Rezoning Transportation Analysis

Petition Number: 2021-119

| Date | Description |
|------------|--------------------|
| 09-23-2021 | First Review (KP) |
| 11-22-2021 | Second Review (KP) |

SHEET NUMBER  
**RZ-1**

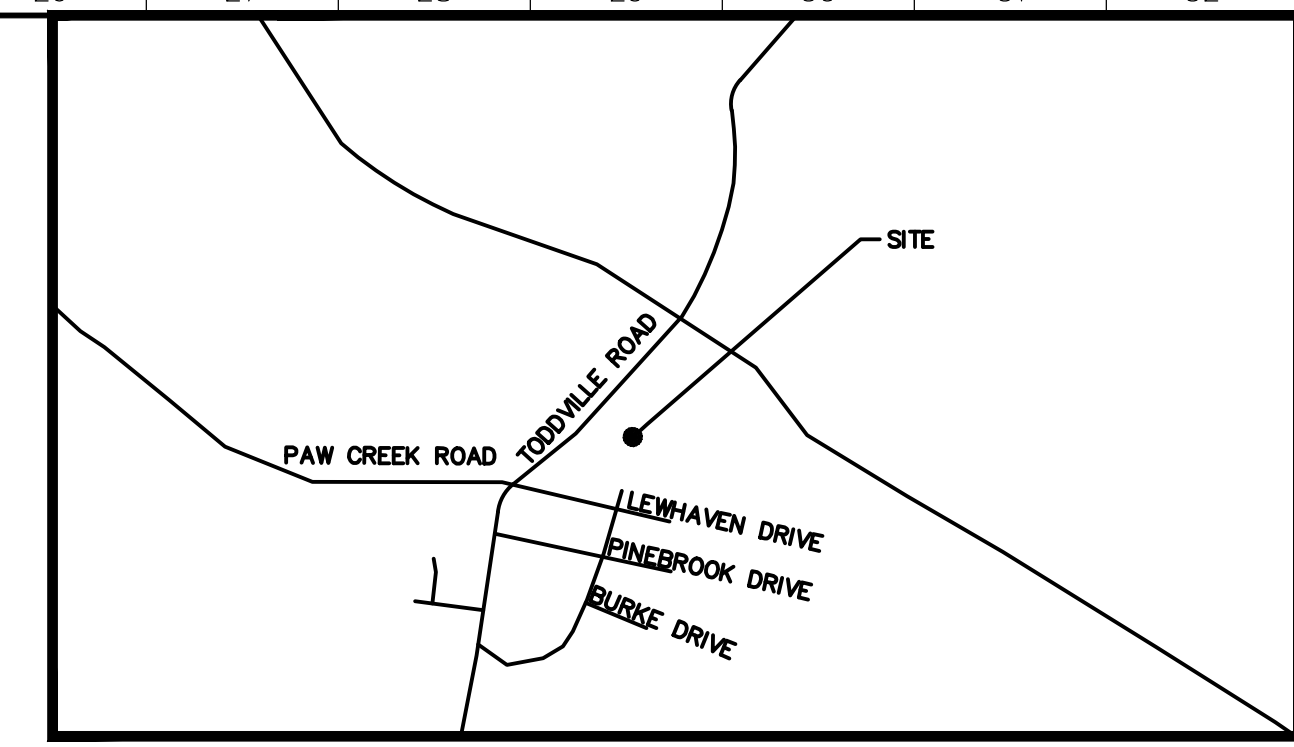
11. **New Comment as a result of the 11-15-2021 Site Plan:** Revise the site plan by modifying the U-02 cross section, shown on sheet RZ-1, to incorporate 6-foot sidewalks as labeled and dimensioned on the site plan.

10. **New Comment as a result of the 11-15-2021 Site Plan:** Revise the site plan and conditional notes to commit to provide right-in right-out ingress and egress at the intersections of Private Alley D and Public Street A and Private Alley A and the approved public street associated with the Freedom Flats Multifamily Development (LDGP-2020-00201). A porkchop island shall be utilized on Private Alley D

and Private Alley A, with appropriate ADA pedestrian accommodations, to direct the right-in right-out movements.

Update to Comment as a Result of the 11-15-2021 Site Plan: Revise Site Plan Note 2 to: "Developer will coordinate with NCDOT, during permitting, to construct a left-turn lane on northbound Freedom Drive to turn onto Woodford Lane. The left-turn lane will be subject to NCDOT standards and approval"
